Stonestreet Green Solar

Statement of Common Ground with the Environment Agency (Tracked)

Doc Ref. 8.3.2(A)

January 2025

Drawing Number	Rev.
011998.00001.709	01

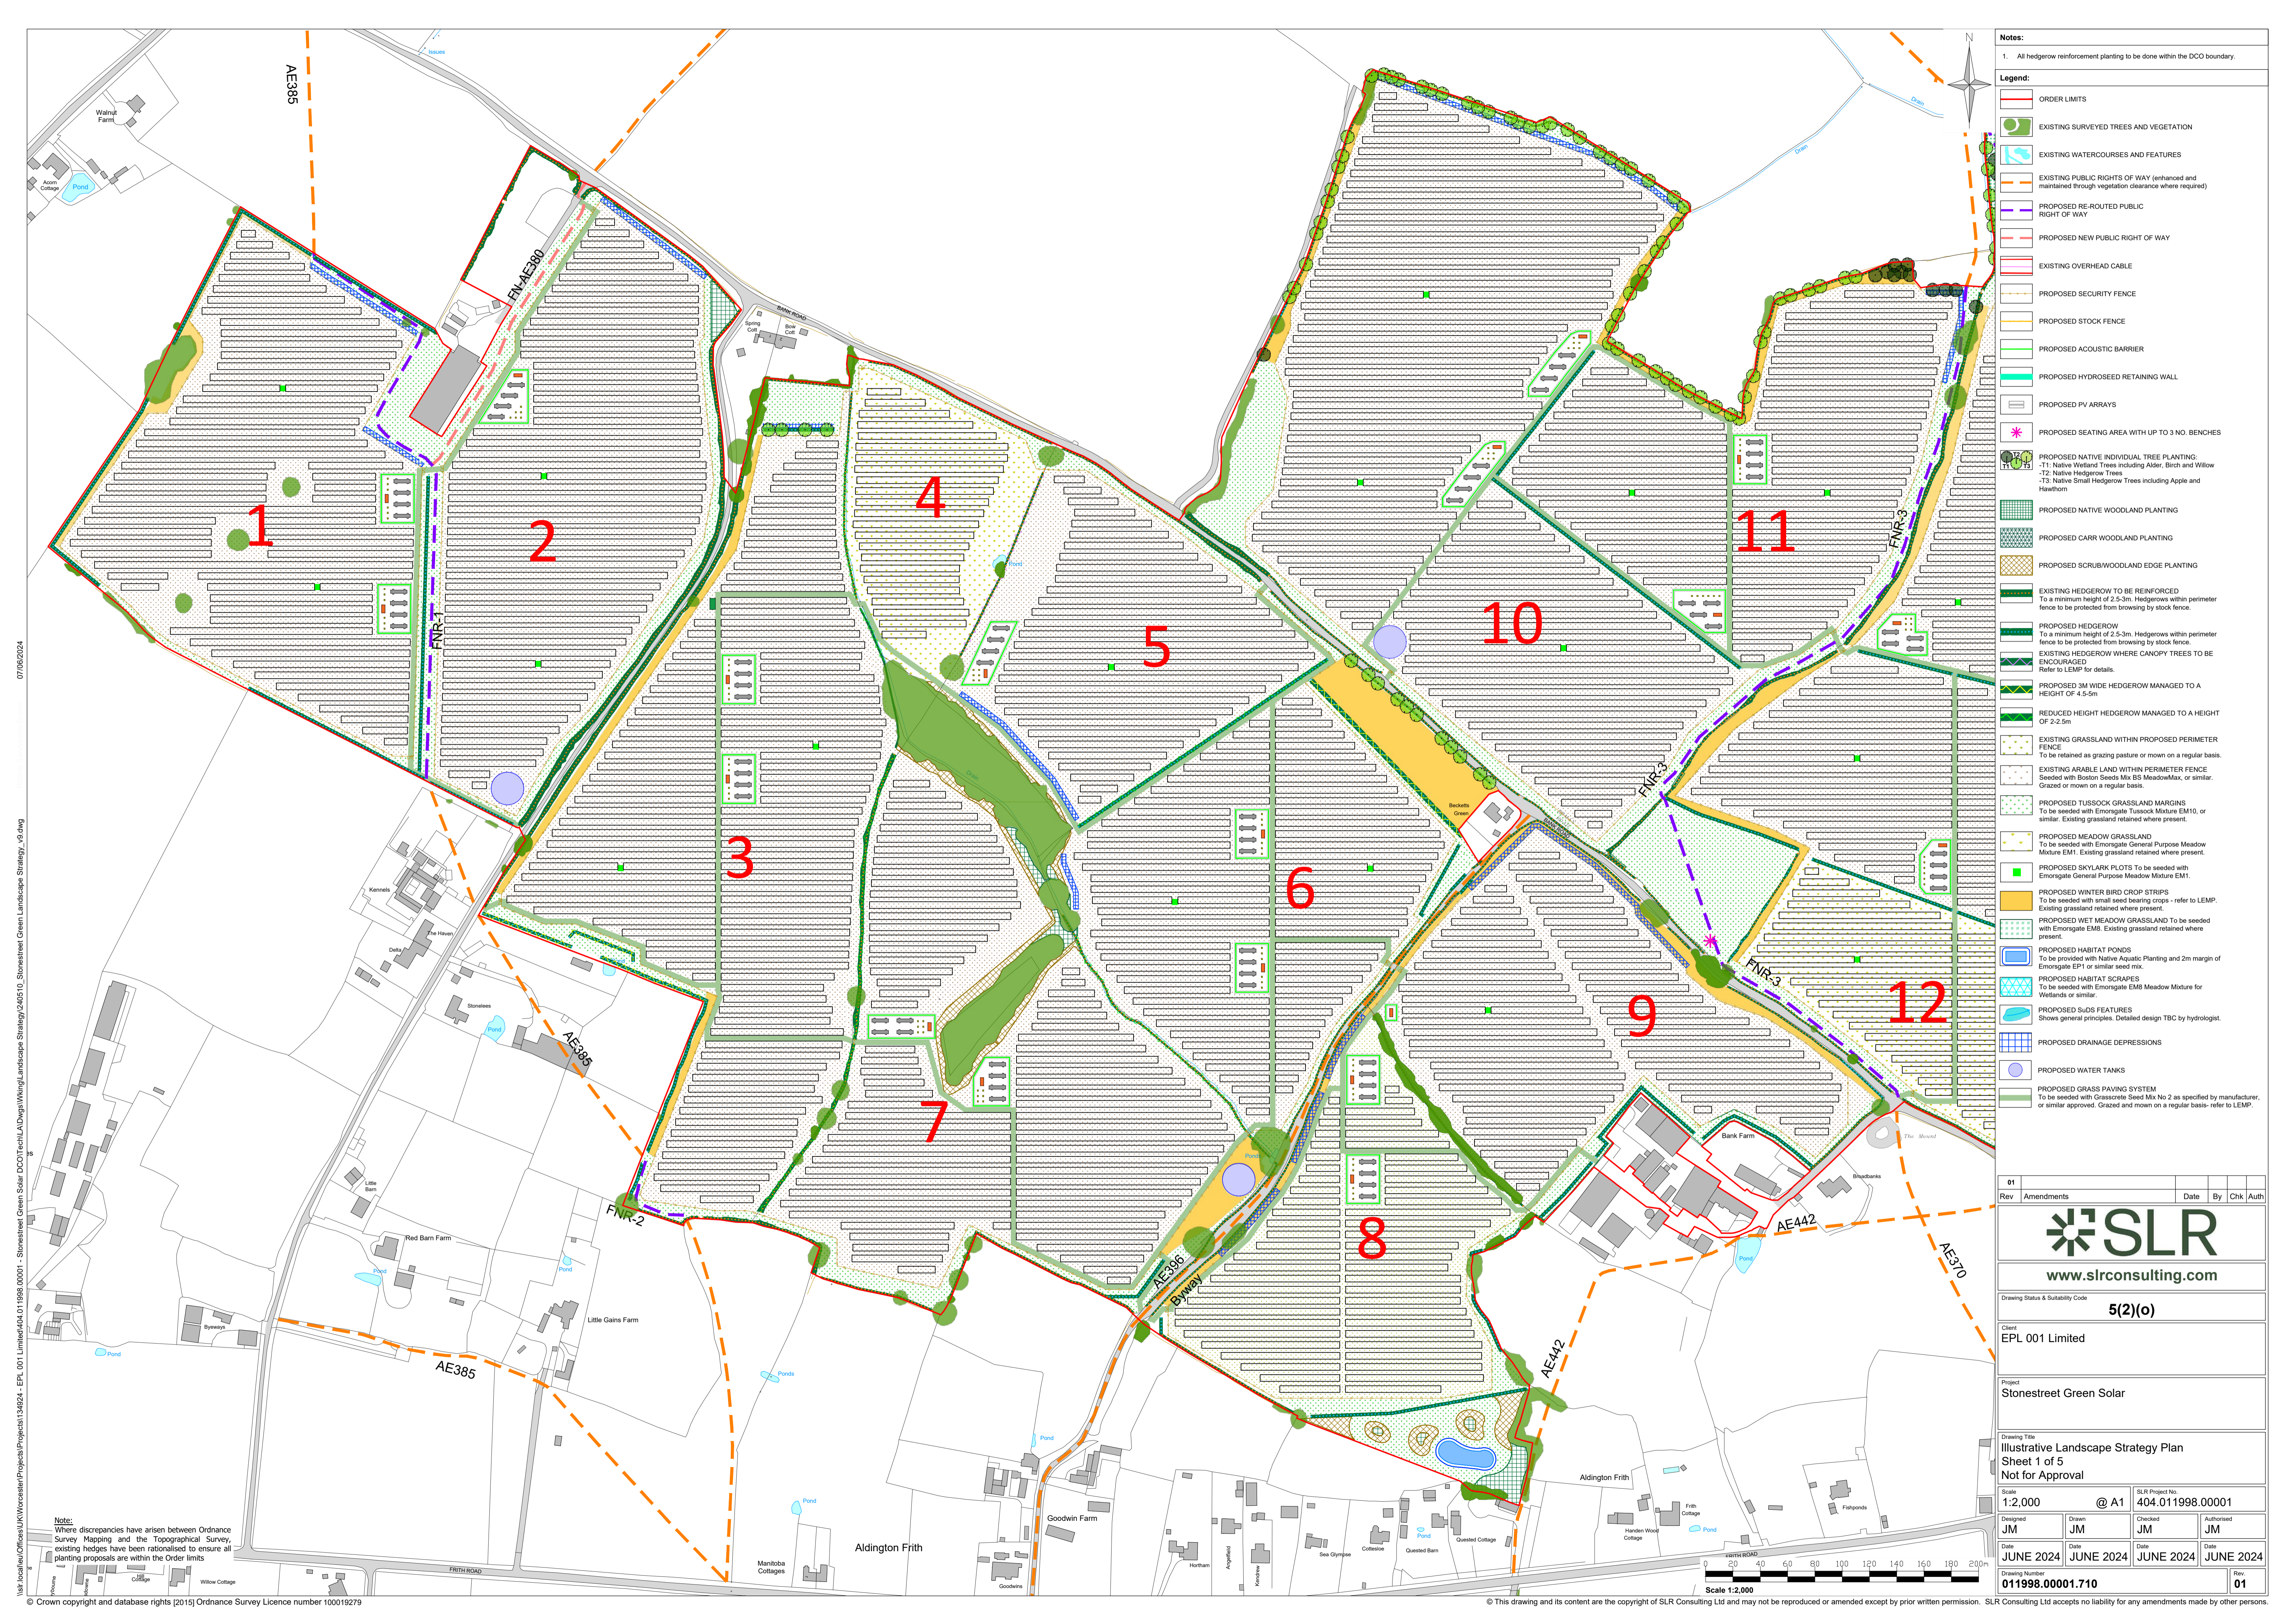
2.10 to 12	RR	Issue 3 - Flood Storage Calculations	<p>Situation: The 'Floodplain Compensation level for Level Calculation' table from 'Annex D: Floodplain Compensation Level for Level Calculations' of the FRA demonstrates a net increase (1,543.11 m3) in flood storage downstream of the Aldington Flood Storage Area but does not show any net increase within Aldington Flood Storage Area as referenced in the Outline Operational Surface Water Drainage Strategy (OOSWDS). Paragraph 5.1.5 of the OOSWDS states "The swale and wetland areas have both been designed to enhance biodiversity and ensure that there is no adverse impact on water quality. In addition, the wetland area, which will be sited within the AFSA, will increase the capacity of fluvial flood storage available. This will therefore contribute to a small reduction in downstream flood risk." (<i>APP-094 – Doc 5.4 Environmental Assessment</i></p>	<p>None of the works proposed within the AFSA involve any build up in ground levels.</p> <p>The works proposed relate to;</p> <ol style="list-style-type: none"> 1. Superficial treatments and vegetation management with a commitment made that vegetation management will be ongoing with any accumulated material removed from the AFSA. Such work would therefore have a neutral impact on flood storage, 2. The provision of fencing around the skylark area in Field 29 as illustrated on the Illustrative Landscape Drawings (Doc Ref. 2.7(A))2.7(A)) [REP1-005] (Sheet 3 of 5 - drawing number 011998.00001.712). The fence posts would result in a negligible loss of flood storage, but at a level that would be difficult to quantify. 3. The creation of ecological scrapes and ponds as illustrated on the 	Under discussion

Ref	Relevant Application Document	Description of Matter	EA Current Position	Applicant's Current Position	Status
			<p><i>Appendix 10.2: Flood Risk Assessment; APP-159 – Doc 7.14 Outline Operational Surface Water Drainage Strategy</i></p> <p>Impact: The storage capacity of Aldington Flood Storage Area may be reduced by the proposed landscaping works.</p> <p>Solution: The applicant should amend the flood storage calculations within the 'Floodplain Compensation level for Level Calculation' table from 'Annex D: Floodplain Compensation Level for Level Calculations' of the FRA to show the flood storage increase inside Aldington Flood Storage Area as stated in the paragraph 5.1.5 of the OOSWDS "increase the capacity of fluvial flood storage available".</p> <p>22/11/2024 (EA) As outlined above when the Outline OSWDS (Doc Ref. 7.14) is updated to include that there will be no net loss of storage capacity within the AFSA this will be conditioned. We have no further comments to make until we have reviewed the requested supporting calculations and updates to</p>	<p>Illustrative Landscape Drawings (Doc Ref. 2.7(A)) [REP1-005] (Sheet 3 of 5 - drawing number 011998.00001.712). These would be formed by excavation only with all spoil removed disposed of outside of the AFSA. As such these works would only increase the available flood storage volume.</p> <p>4. The creation of the wetland area which will receive storm runoff from the Project Substation. This will be formed by excavation and will not involve impounding water to a level above the existing ground surfaces. As such the formation of this feature can only increase the volume of flood storage available.</p> <p>The net effect of these works will clearly be an increase in the available flood storage volume within the AFSA. On this basis no further assessment was deemed necessary.</p> <p>In response to this comment work is however now being undertaken to quantify the changes resulting from items 2, 3 and 4 above. This additional detail will be included within Environmental Statement Appendix</p>

Ref	Relevant Application Document	Description of Matter	EA Current Position	Applicant's Current Position	Status
			<p>Environmental Statement Appendix 10.2: Flood Risk Assessment (Doc Ref 5.4)</p>	<p>10.2: Flood Risk Assessment (Doc Ref 5.4(A)). <u>This additional detail will be included within ES Appendix 10.2: Flood Risk Assessment (Doc Ref 5.4(A)) [REP1-036] [REP1-037] and [REP1-038].</u> The updated document will be provided by Deadline 1.</p> <p>In addition, the Applicant will also amend the Outline OSWDS (Doc Ref. 7.14(A)) [REP1-054] to include a commitment to ensure no net loss of storage capacity within the AFSA.</p> <p><u>The Applicant awaits the EA's confirmation that the updates to the Outline OSWDS (Doc Ref. 7.14(A)) [REP1-054] are acceptable.</u></p>
